SSD DA Response to GA NSW Comments

30 January 2018 Rev 3

MB SSDA-12

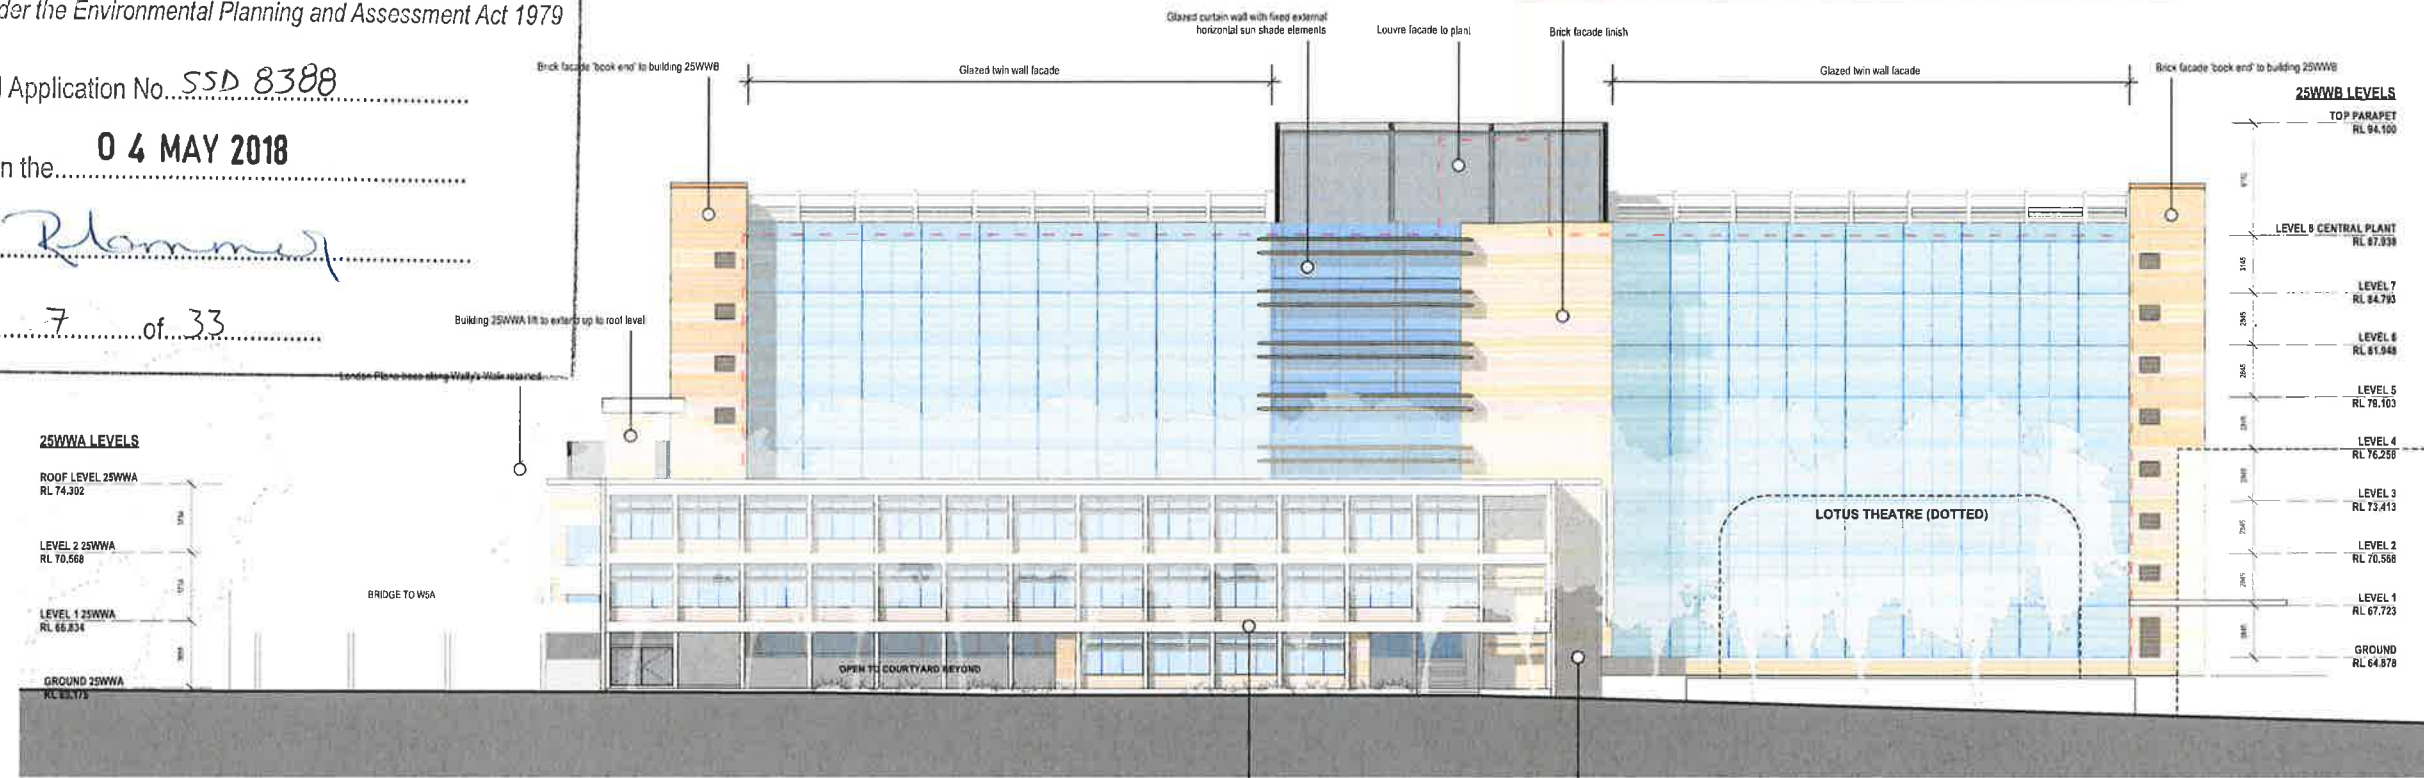
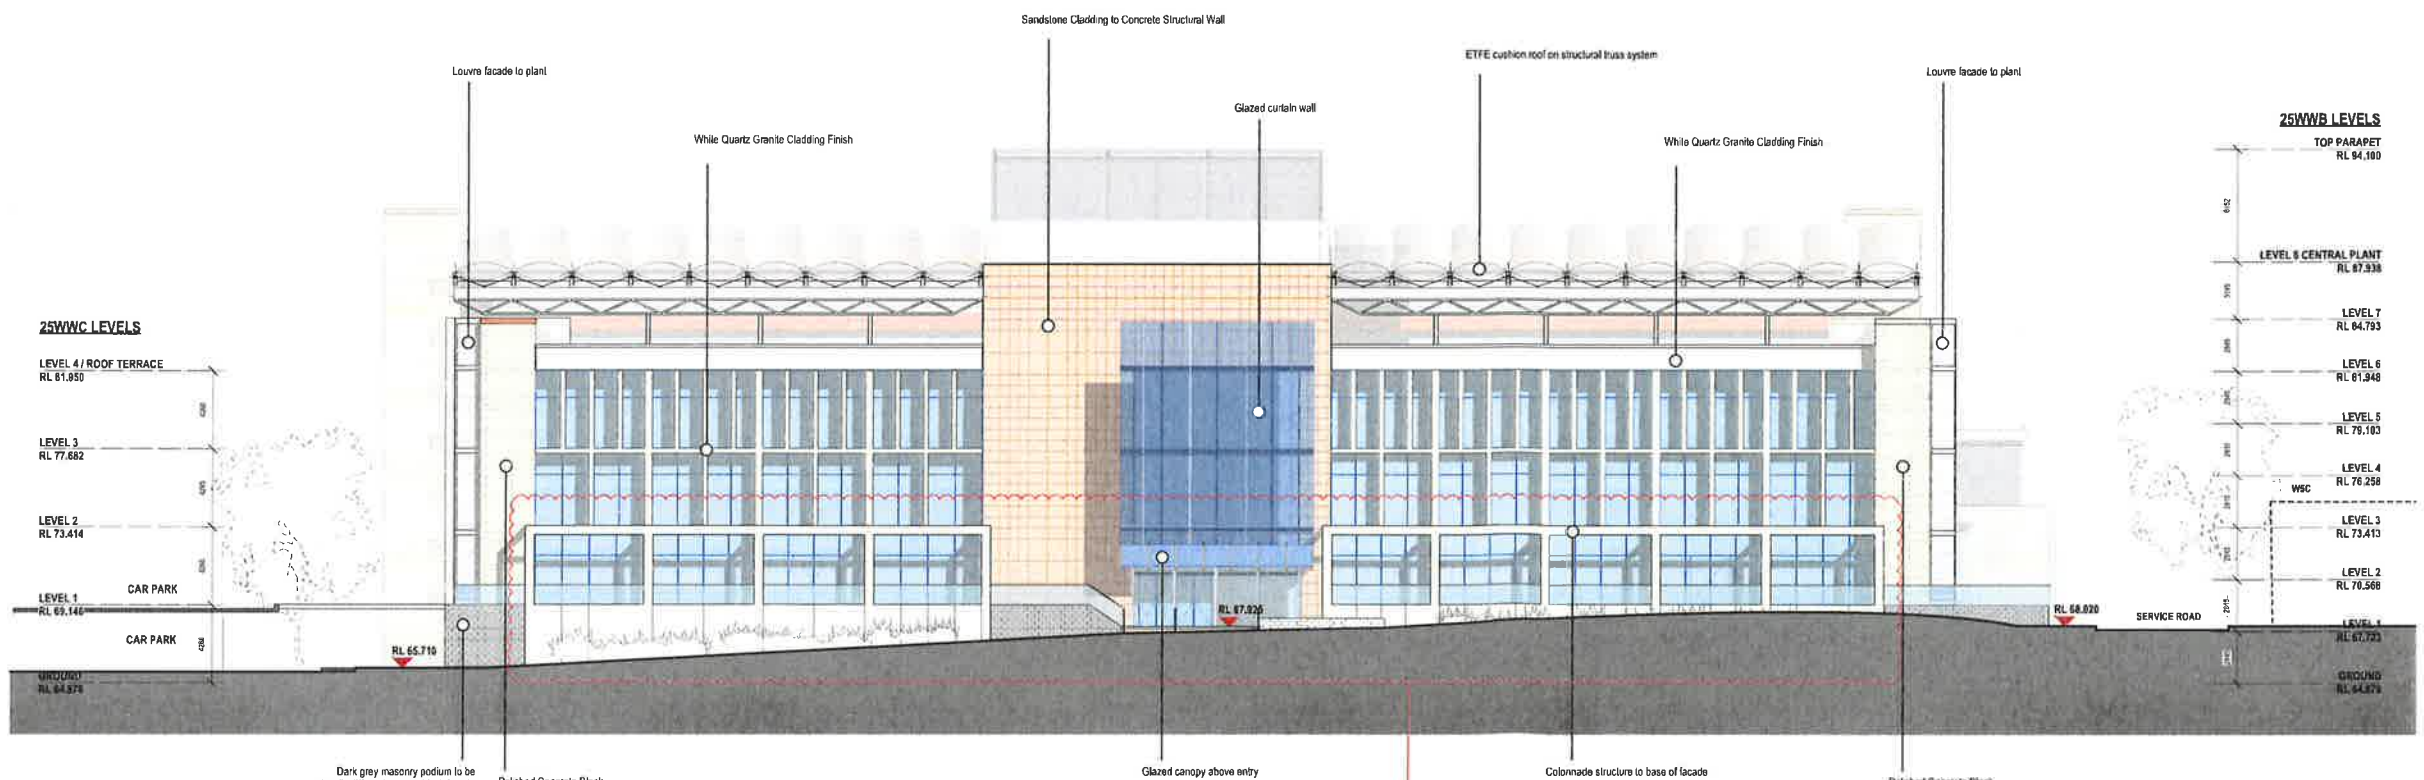
The following SSAD DA Architectural drawings have been amended and are now resubmitted to coordinate with the now developed and advanced landscape drawings:

- SSDA-02B Site Analysis Plan
- SSDA-03B Proposed Ground Floor Plan – All Buildings
- SSDA-05B Proposed Floor Plan/Level 2 - 25WWA & 25 WWB/
Level 1 - 25 WWC
- SSDA-06B Proposed Floor Plan/Roof Level – 25WWA/Level 3 –
25WWB/Level 2 – 25WWC
- SSDA-12B North Elevation South Elevation
- SSDA-13B East Elevation West Elevation
- SSDA-22B Materials and Finishes

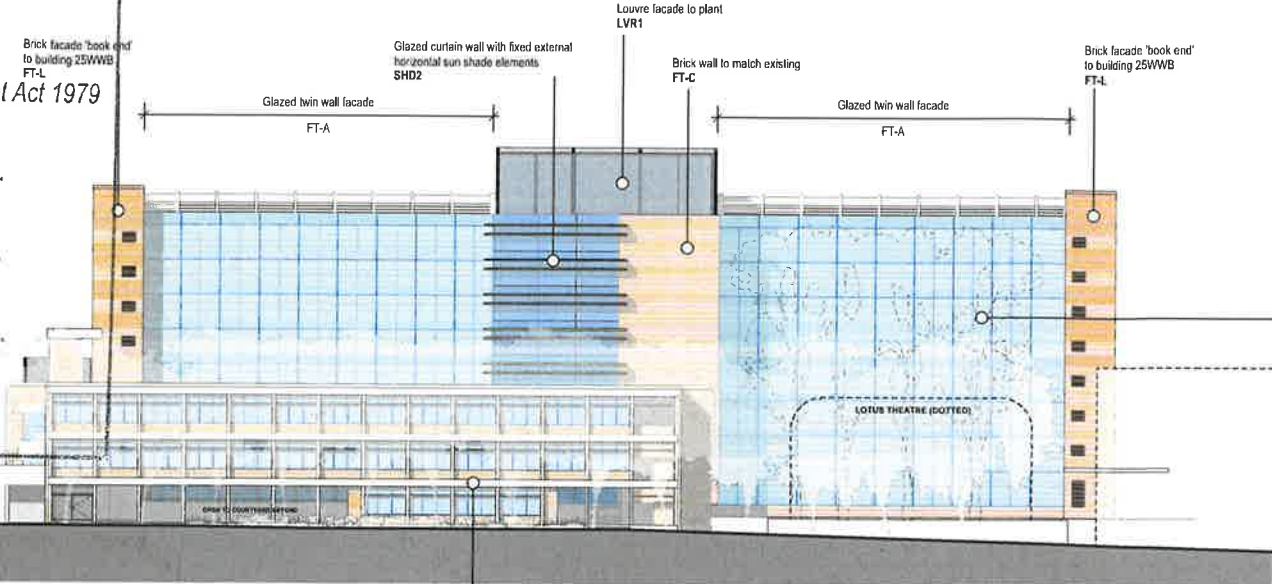
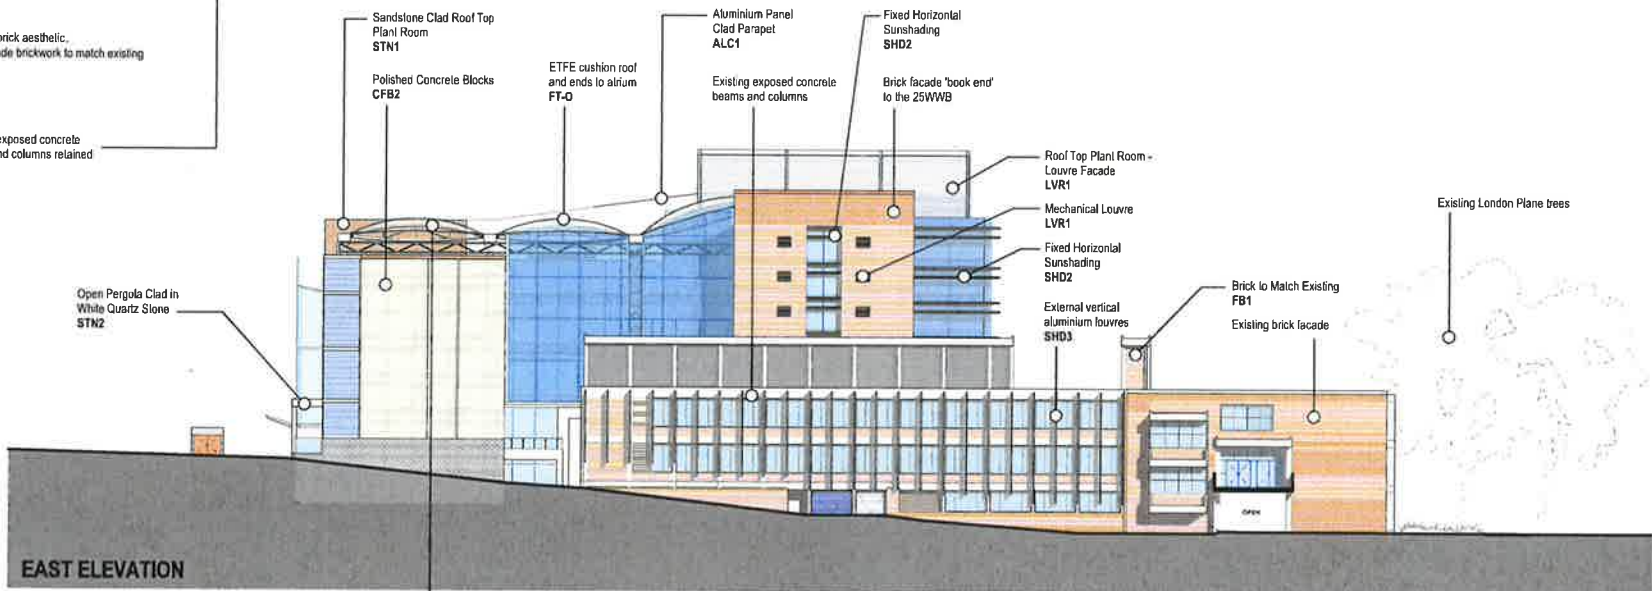
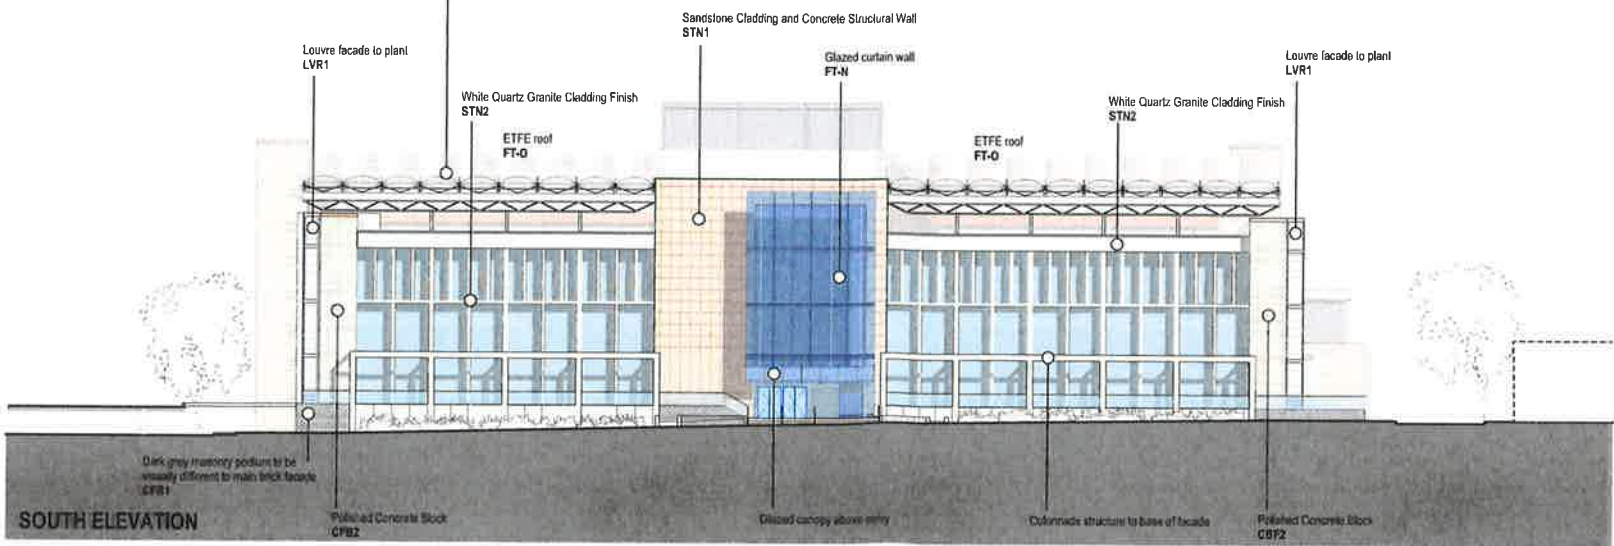
1.6 Materials and Finishes Drawing

Architectural Drawing SSDA-22B has been upgraded to include more specific material coding and drawing SSDA 23 has been added to include photographs of the actual external Finishes Material Sample Board and the External Materials Schedule to illustrate all significant façade/external materials.
